Application No: FP/134/25/HH
Site Address: Old Watch House Old Coastguards Felpham PO22 7BJ
Description of works: Demolition of the existing garage and replacement with new store and residential annex to the main house.

Thank you for your internet representation made on 23rd October 2025 which has been recorded as an objection with the comments as follows:

Project: The Watch House
Old Coastguards
Felpham
PO22 7BJ
Client: Mrs Mountain
Drawing Title: Proposed Elevations & Upper Floor Plans

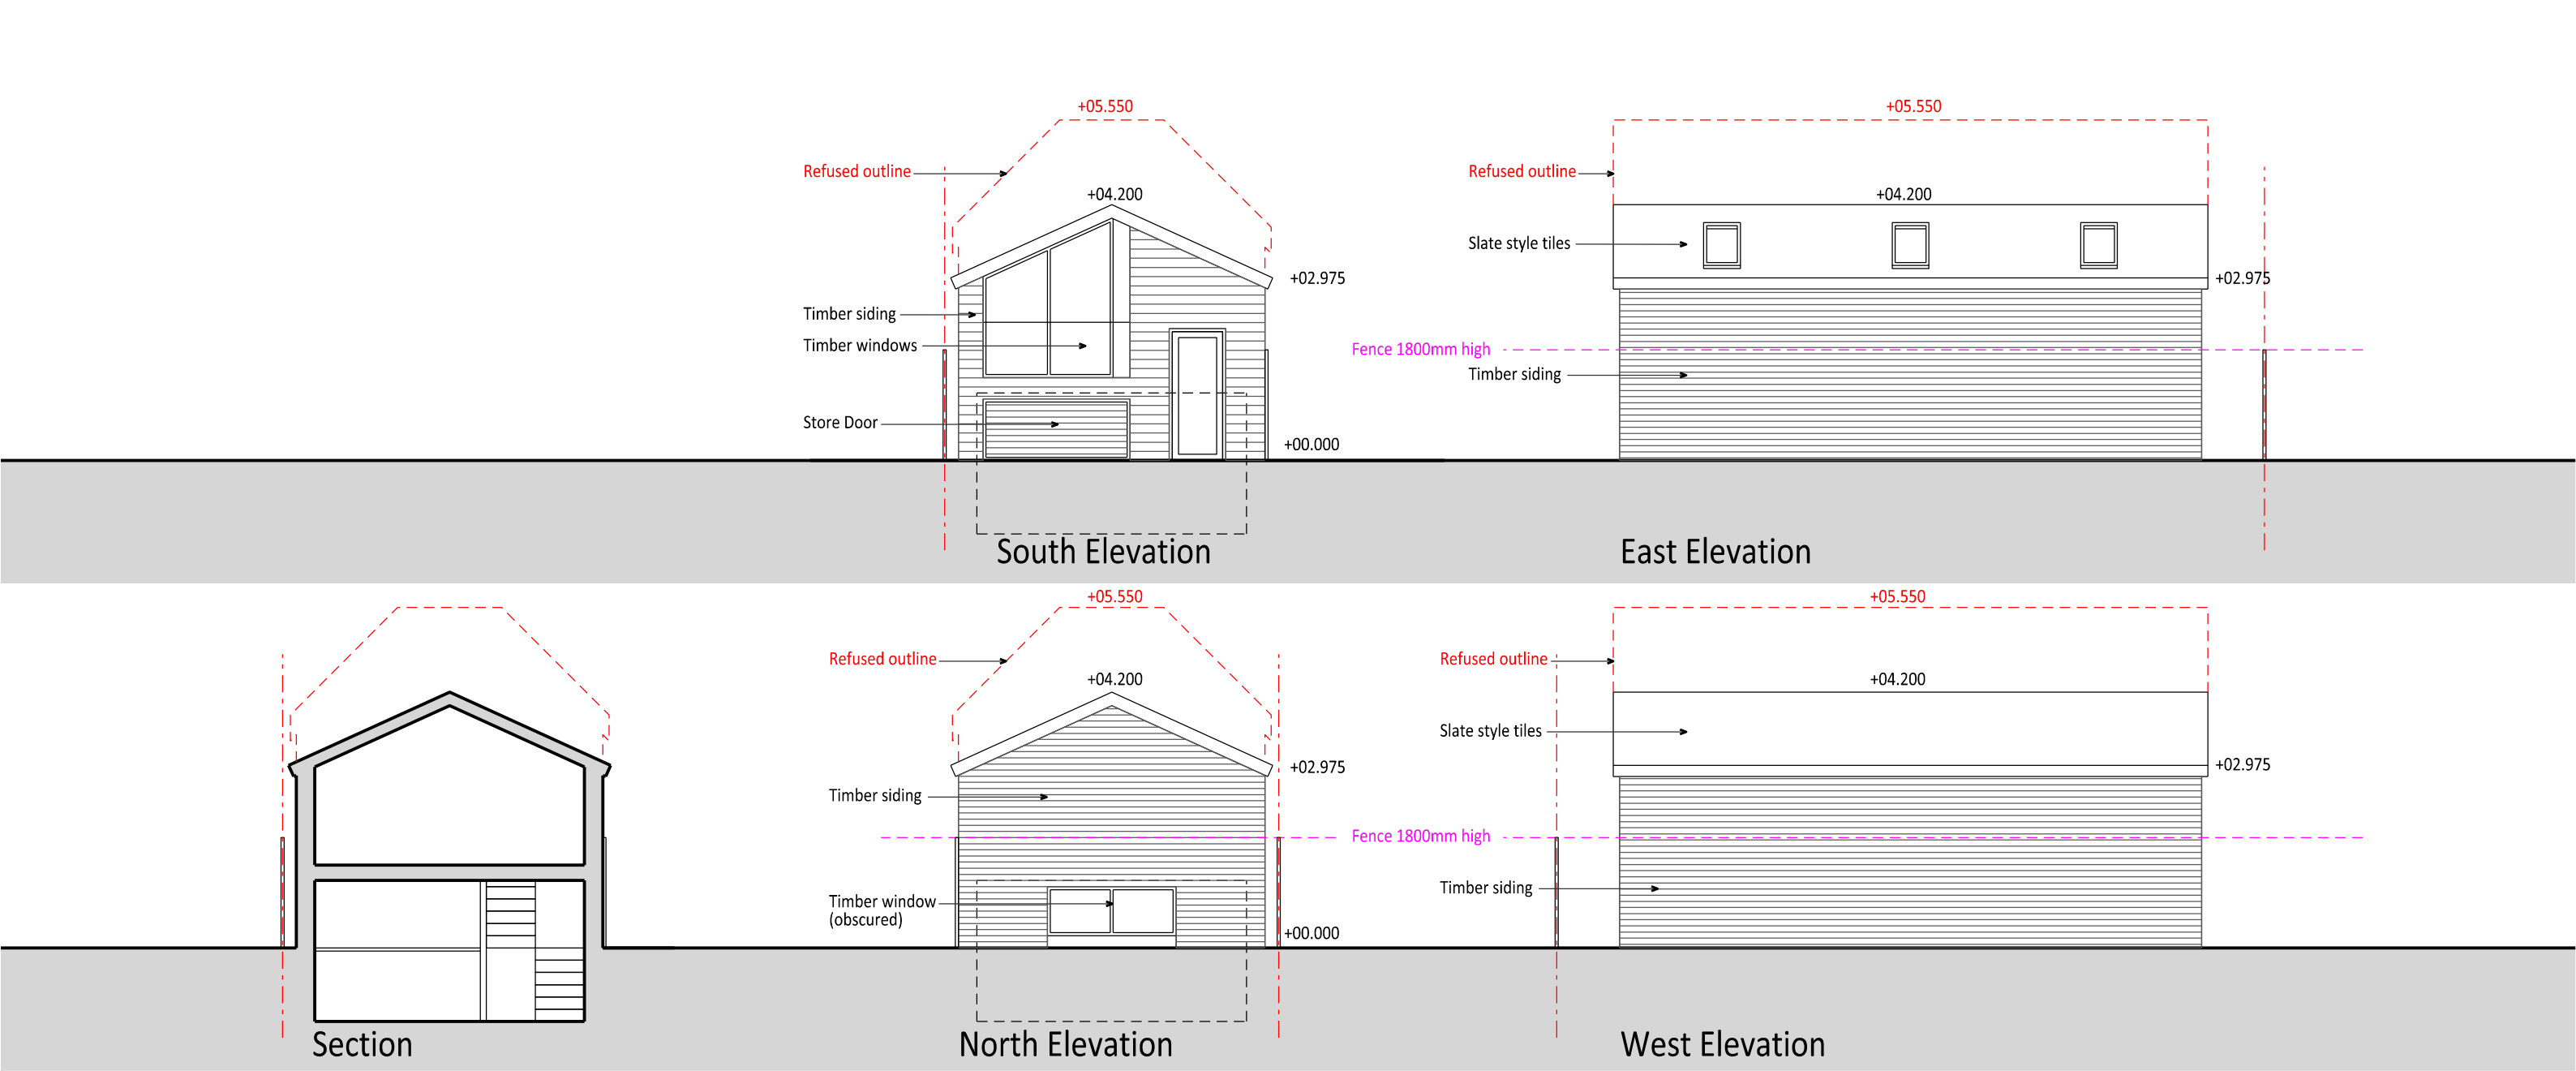
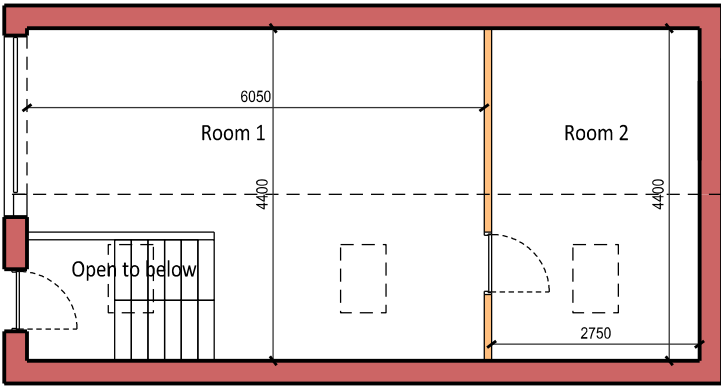
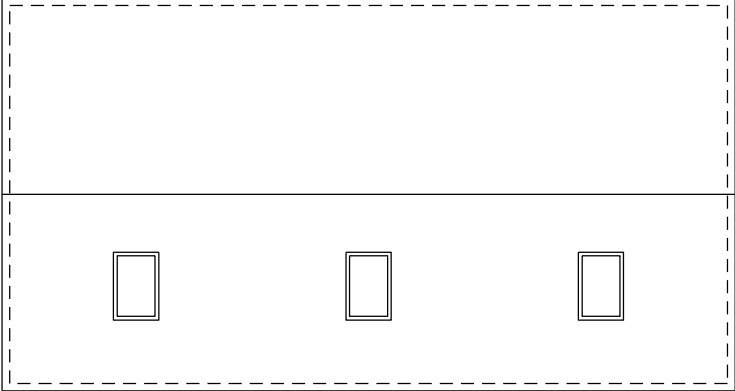
i,am writing this to strongly object to the planned building works at the watch house . the planned structure would be directly behind my property enclosing my rear garden restricting views and sunlight and i have also noticed that the roof windows would have a direct sightline into our bedrooms restricting privacy . the planned cladding of the building would not sit within the old style of builds already here . the additional visitors would also be taking extra parking and travel up the drive way which is also our only access via footfall to our house. we moved to this house as it was quiet , peaceful and private and we consider this new additional dwelling would impact this
